WEST SUSSEX COUNTY COUNCIL CONSULTATION

TO:	Arun District Council FAO:R. Castro-Parker
FROM:	WSCC - Highways Authority
DATE:	3 April 2019
LOCATION:	107 Felpham Way Bognor Regis PO22 8QB
SUBJECT:	FP/32/19/PL Conversion of part retail unit & storage area to form 9 No. residential units consisting of 3 No. 1 bed & 6 No. 2 bed dwellings & new access to rear.
RECOMMENDATION:	More Information
S106 CONTRIBUTION TOTAL:	£N/A

SITE PLAN (Proposed) @ 1:200

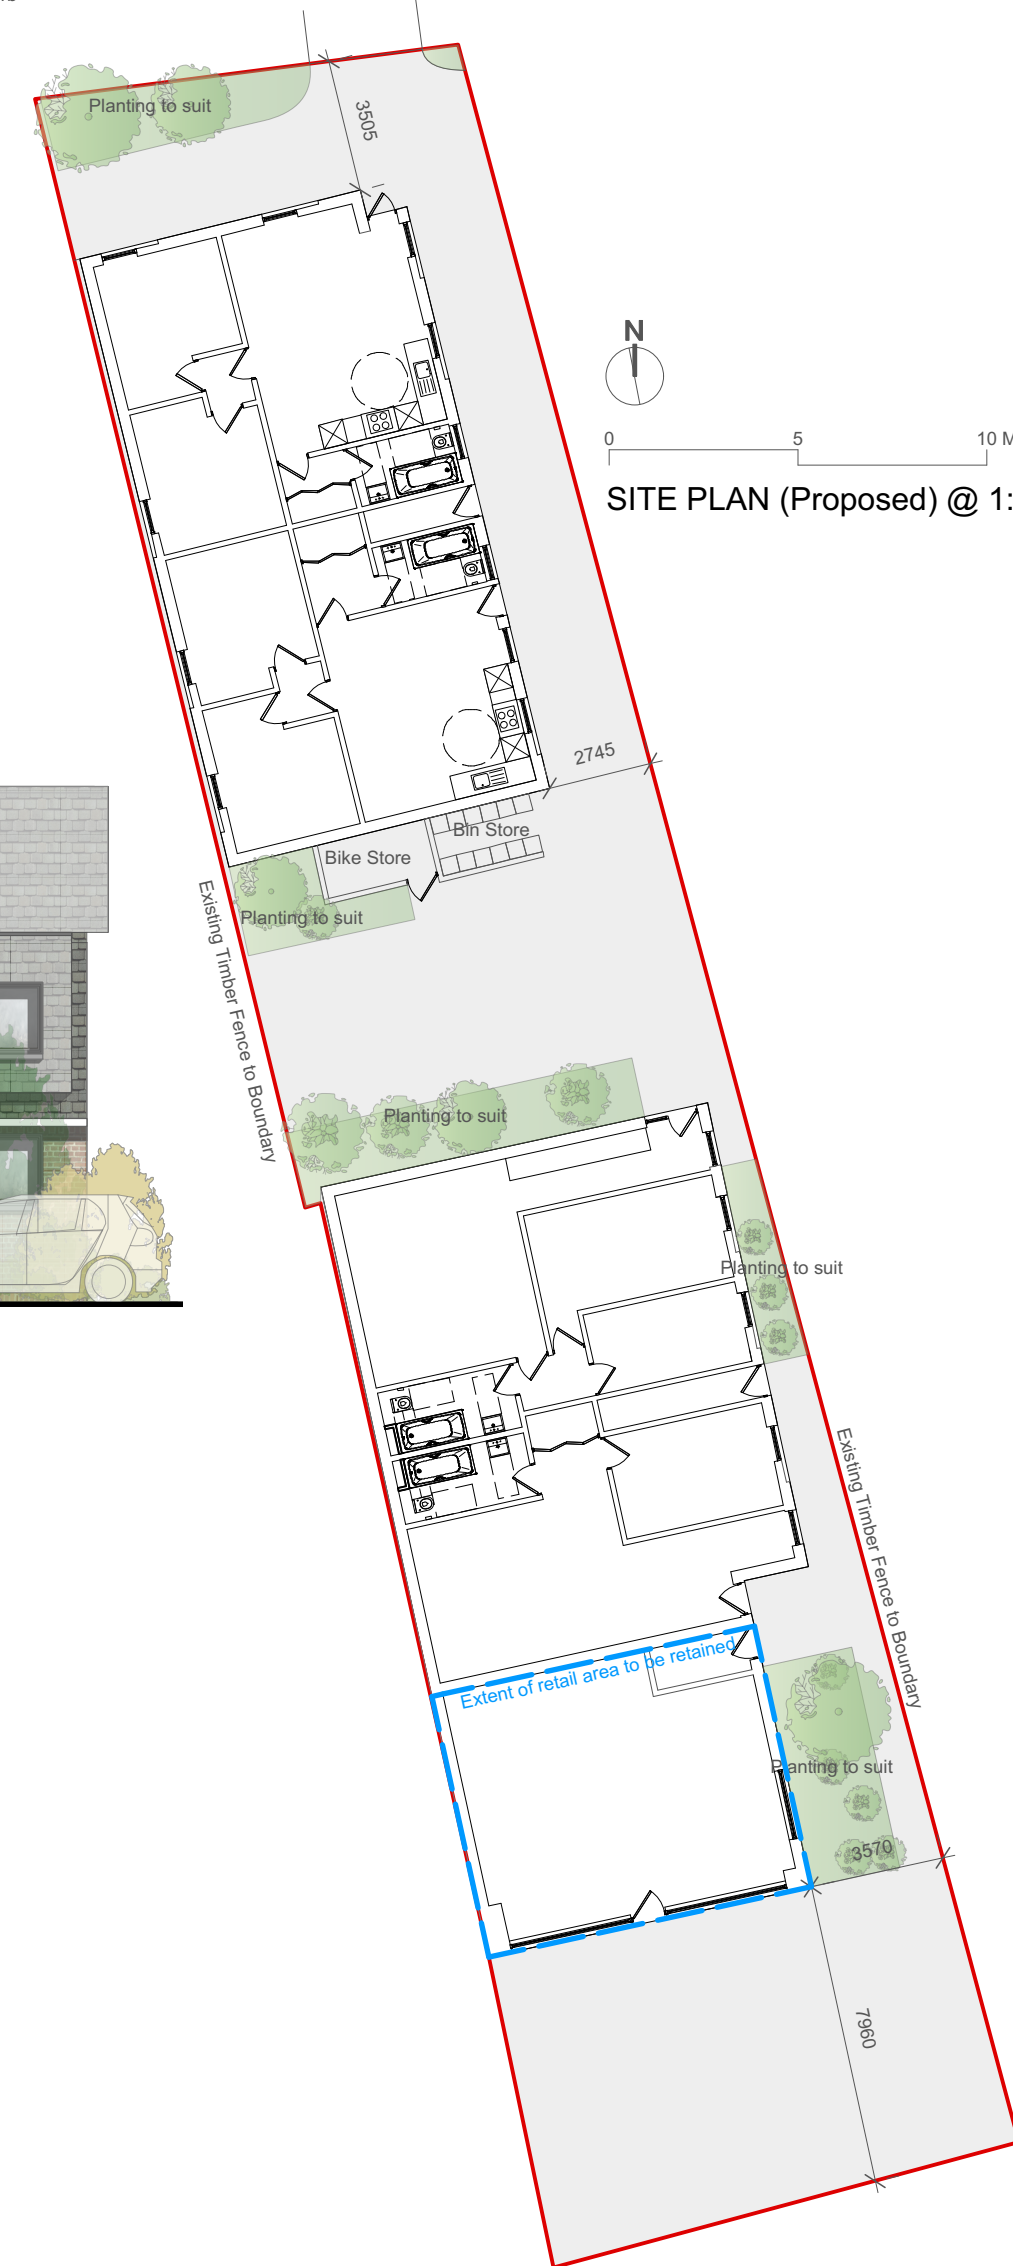
The site is accessed via a vehicle crossover from Felpham Way. The Application Form states that access alterations are proposed but it is not clear what these comprise. It would appear that a new VCO from the north is proposed, from the privately maintained Flax Mean. The applicant should obtain permission from the proprietor of the private road for any access works. It is not clear whether the existing access to the public highway (Felpham Way) will be modified or whether parking is proposed on the frontage for the retail/ residential use.

It is not clear whether the proposed access route within the site, accessed via Flax Mean, is for vehicular use. This is approximately 2.5m at its narrowest which is not sufficient for two cars to pass. It has not been demonstrated that a car can enter and turn on site and is not clear whether any off-street parking is proposed from the rear. There does not appear to be a Design & Access Statement to clarify these matters.

It is not clear from the plans and documents whether any off-street parking is proposed. The applicant should clarify these matters.

The applicant should clarify the proposed access and parking arrangements in order for the LHA to fully assess the proposals. Please ask for this additional information and re-consult.
